Mark Warwick
Tree Officer, Greenspace Team

Planning Application Ref: Y/158/21/PL

Location: The Steddles, North End Road, Yapton, BN18 0DT

Description of works: Demolition of existing dwelling and outbuildings and construction of 11 No dwellings (net increase 10 units) with access, landscaping and associated works (alternative to approved Y/121/19/PL). This site is in CIL Zone 3 and is CIL Liable as new dwellings & is a Departure from the Development Plan

Appendix 1 - Tree Constraints Plan & Tree Retention & Protection Plan

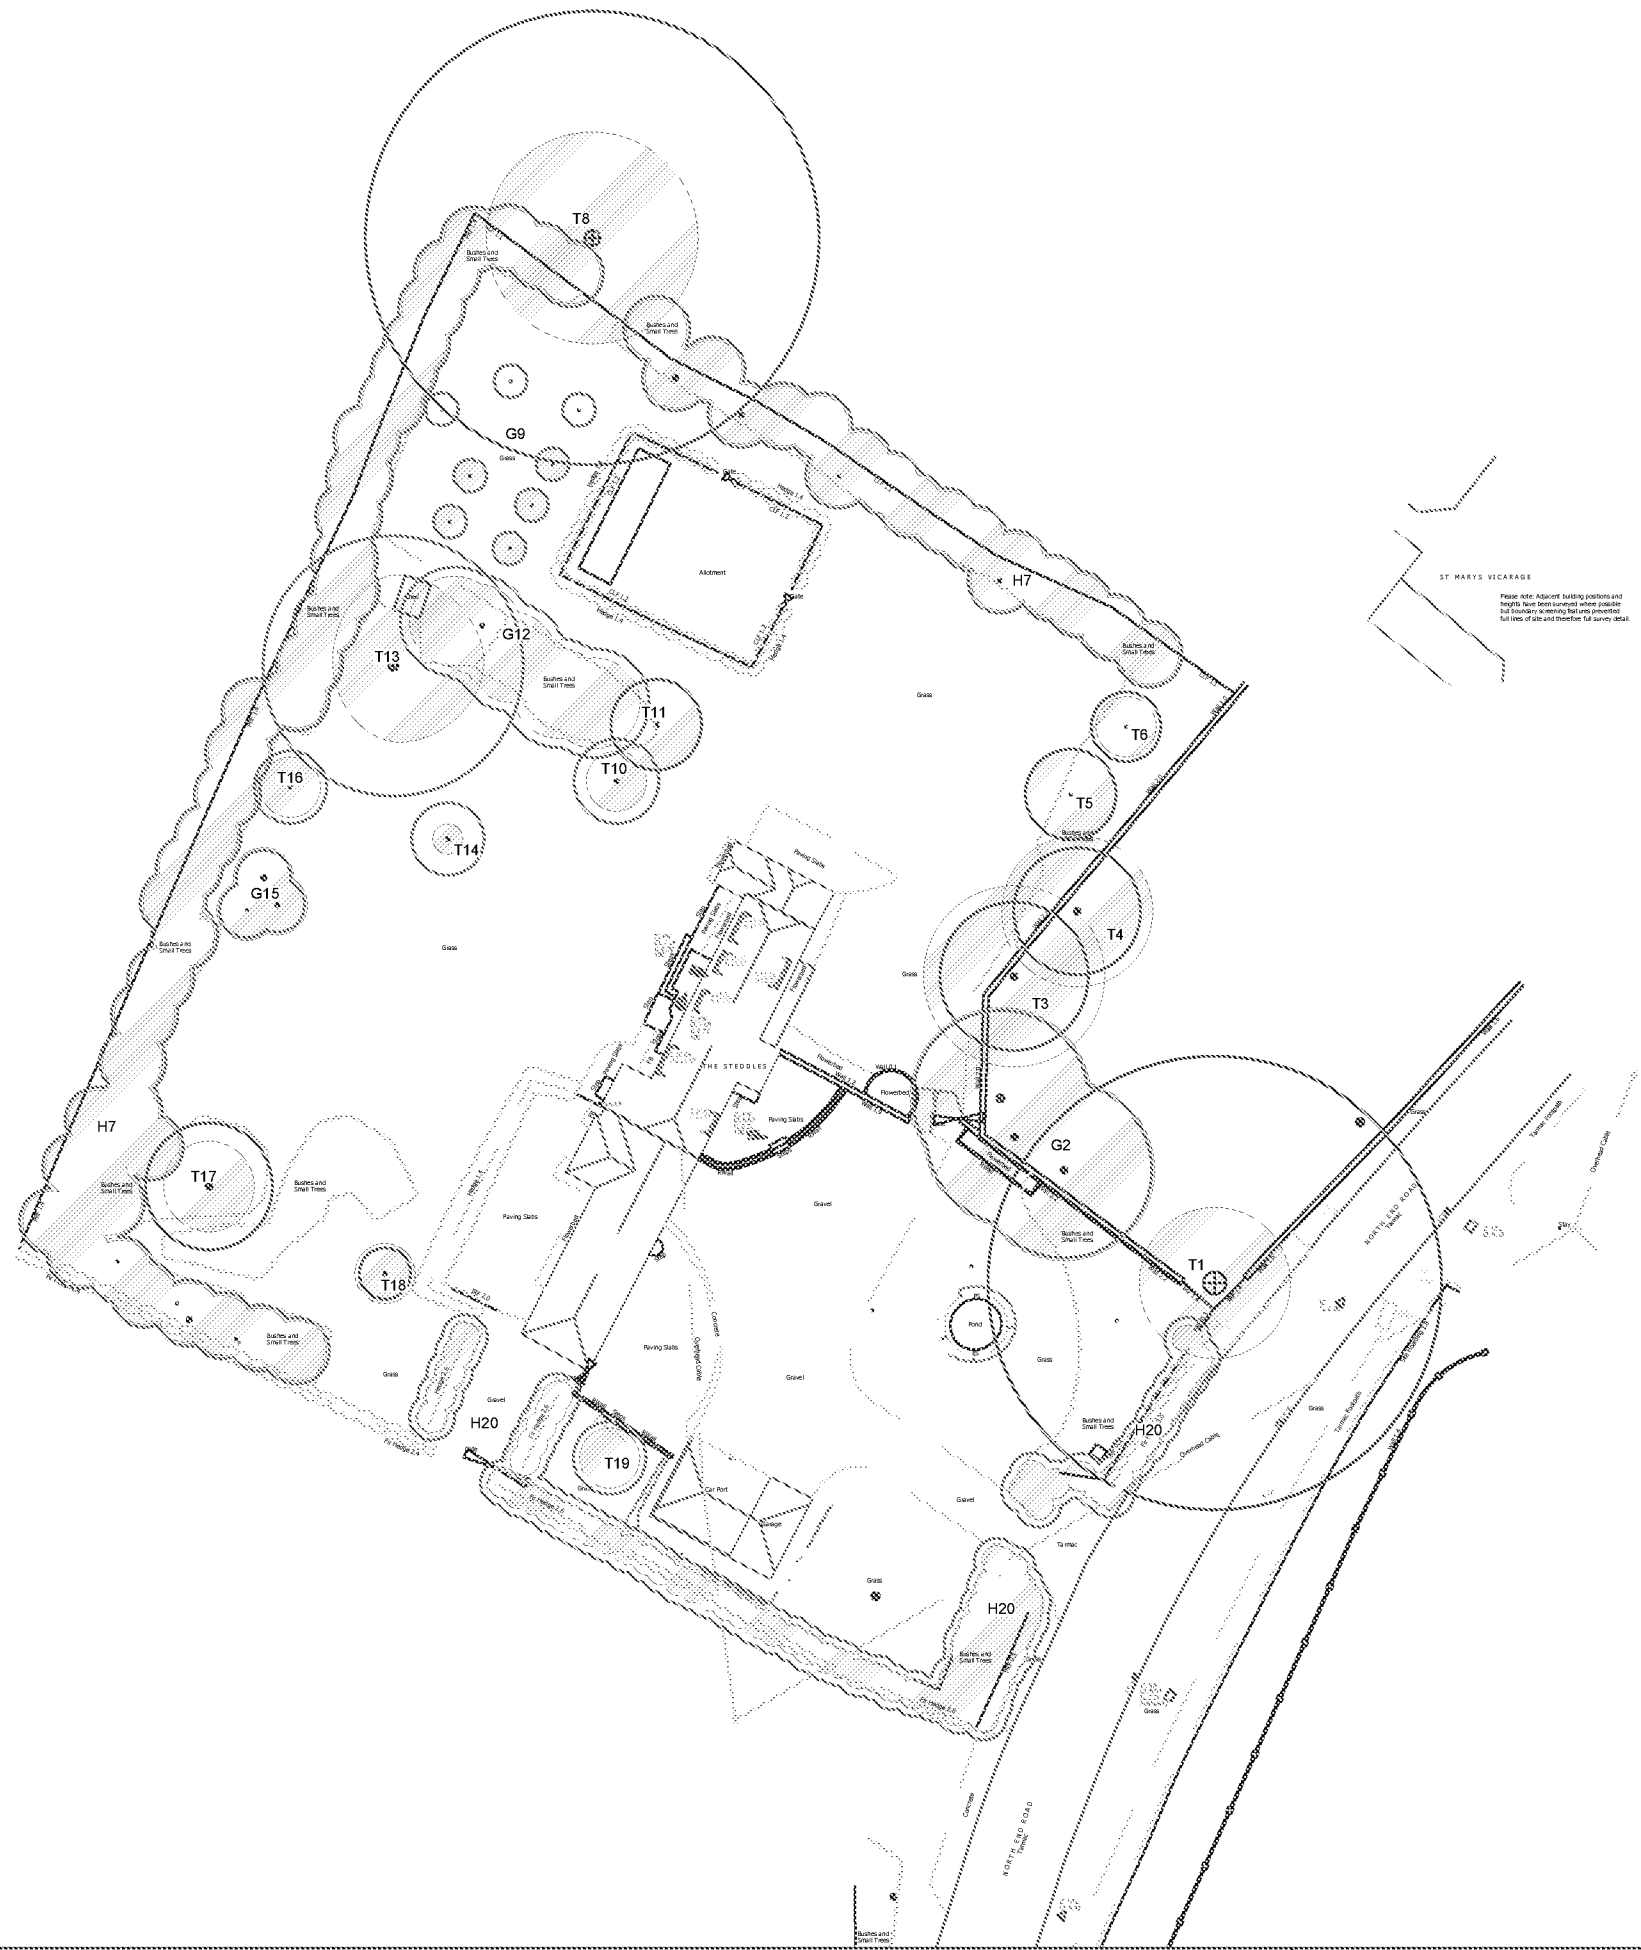
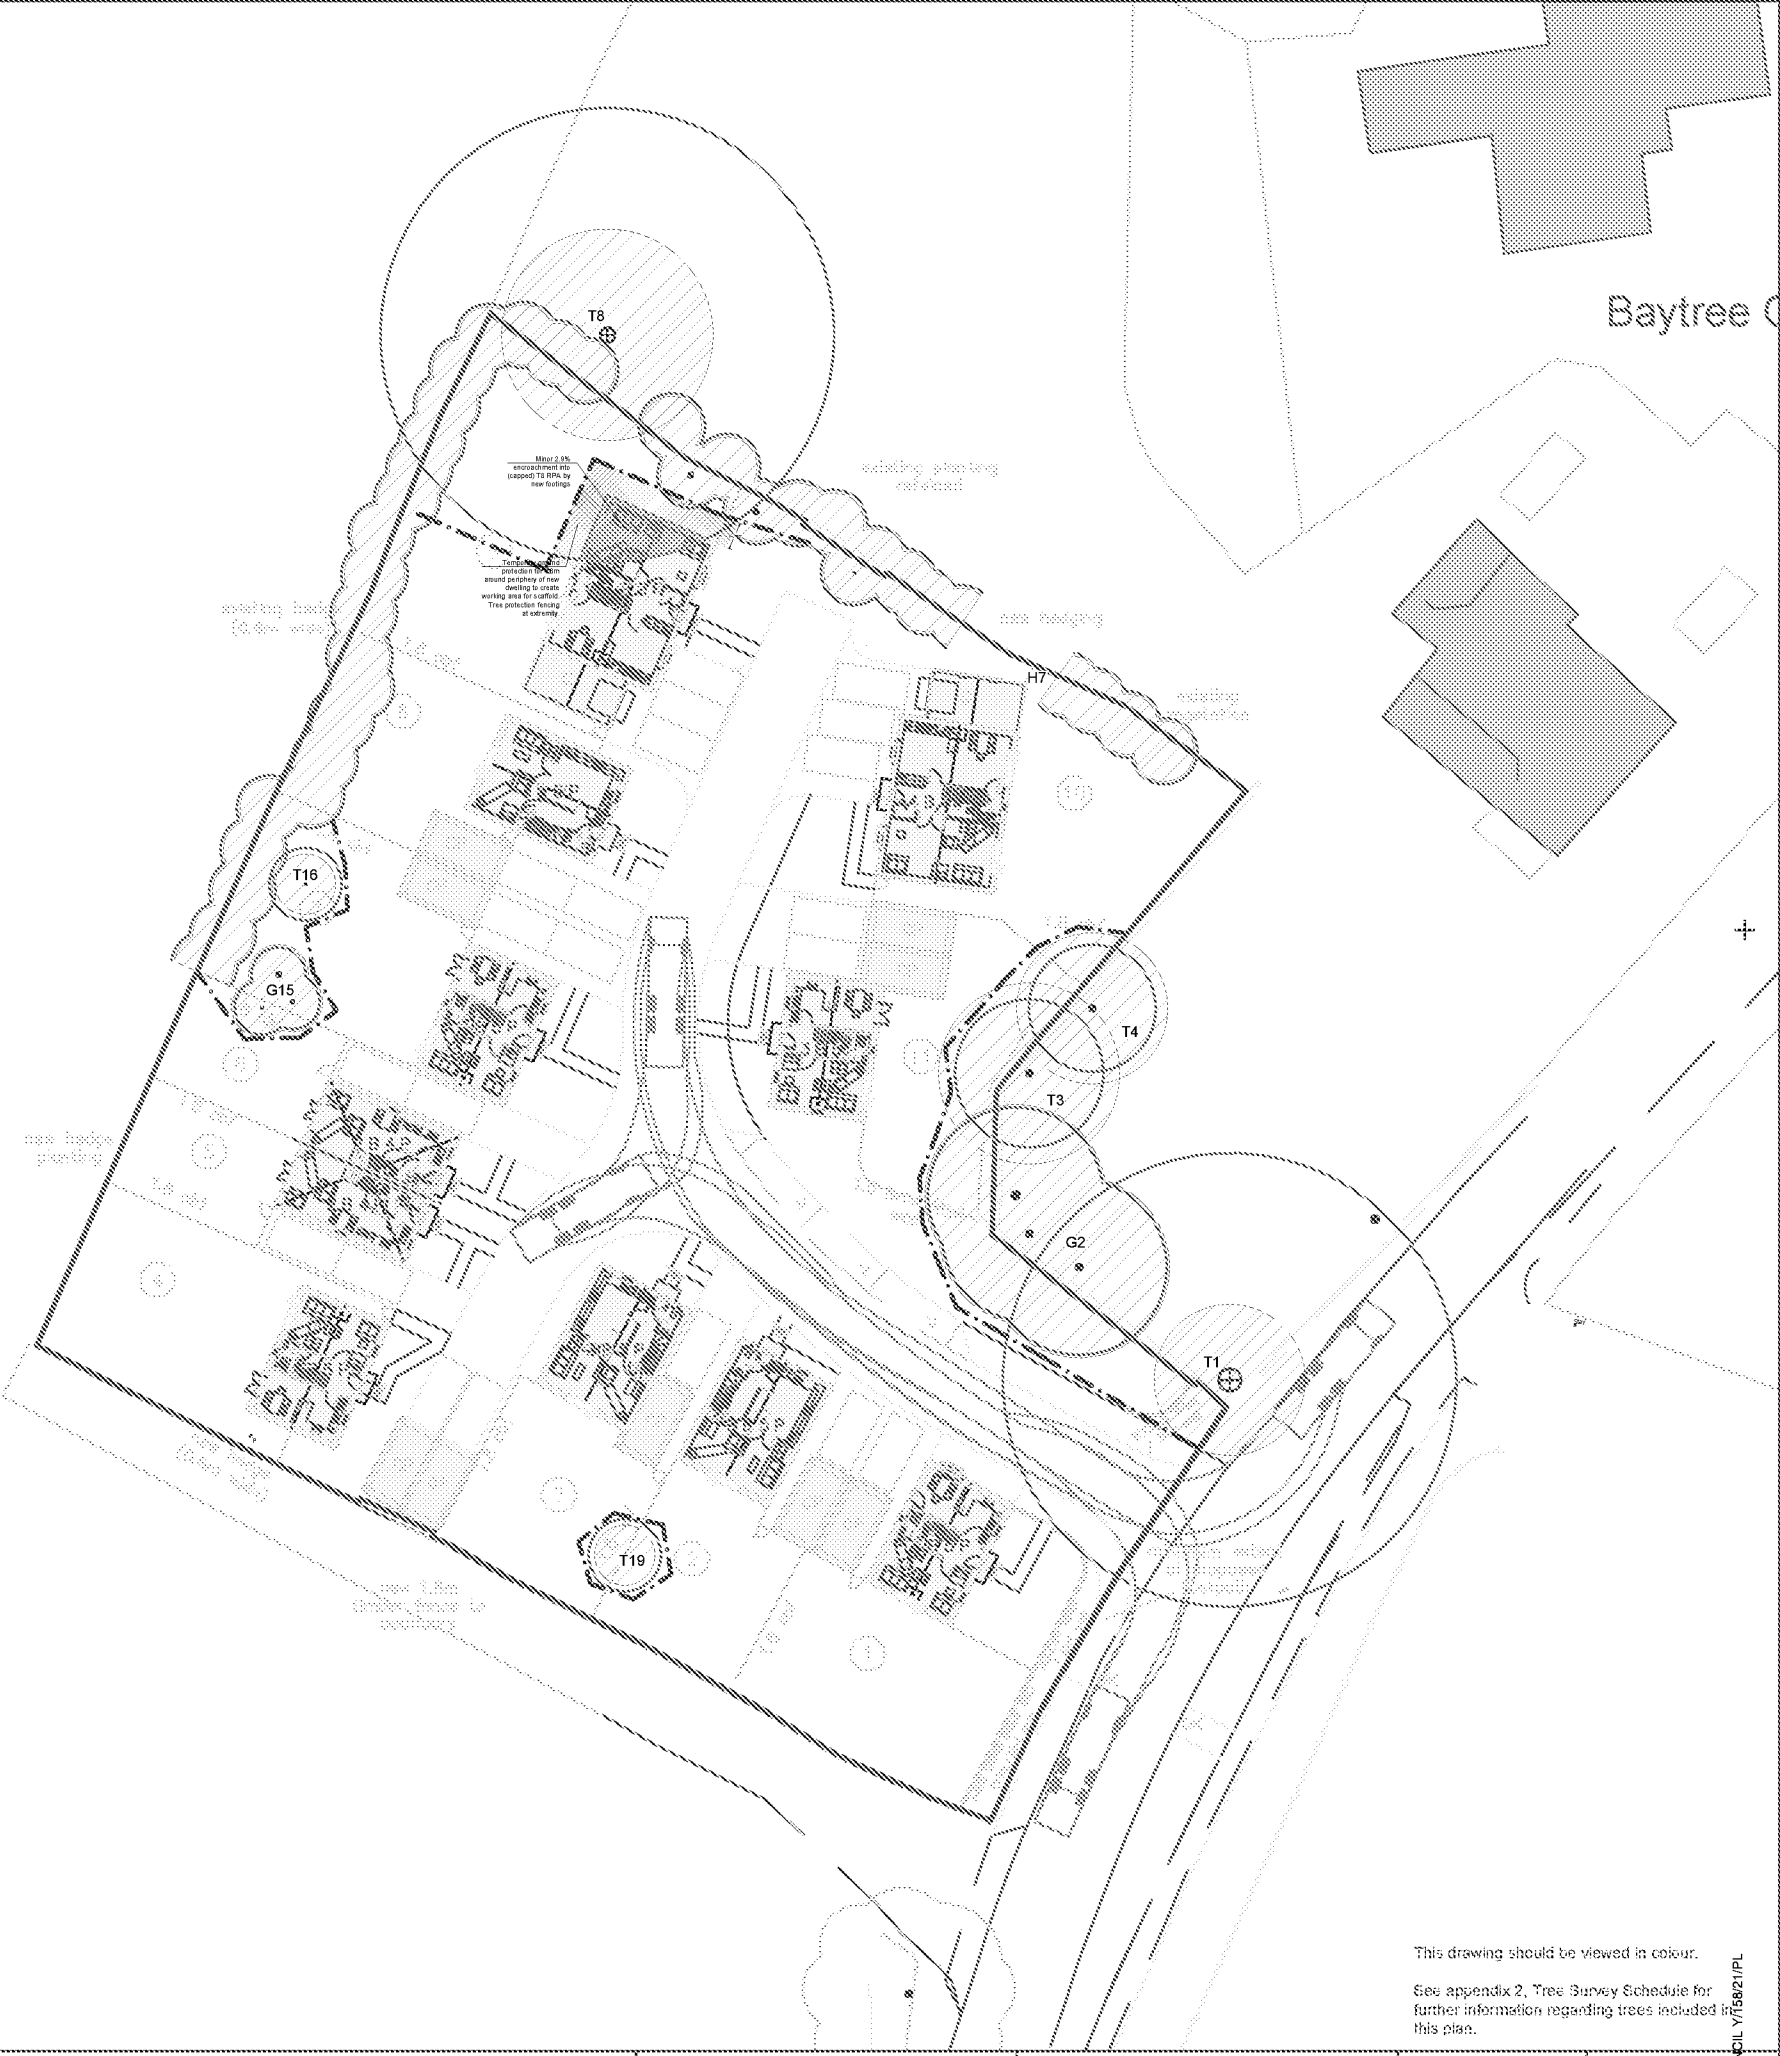
- I also concur with his view that the nominal root protection area (RPA) of T1 as shown, demands an excessive area of soil volume necessary to ensure its ongoing health and vitality, although I welcome the proposed supervision (by the project arboriculturist) of driveway works within the same (see above AIA & MS).

- I recommend the above scheme for **APPROVAL**, subject to the following conditions being applied:
 1. Before the site is occupied or any machinery is introduced to the site or demolition work or construction work or alterations to existing ground levels takes place a **PRE-COMMENCEMENT Site Meeting** is to take place between the Planning Authority's Tree Officer and the Arboricultural Expert or other designated competent person representing the site owner(s) – at this meeting all protective fencing and ground protection measures will be inspected to verify they are 'Fit for Purpose' as required under British Standard 5837:2012 and have been erected and positioned exactly as shown on the **Tree Protection Plan, dwg. no. 2382-02-P2**.
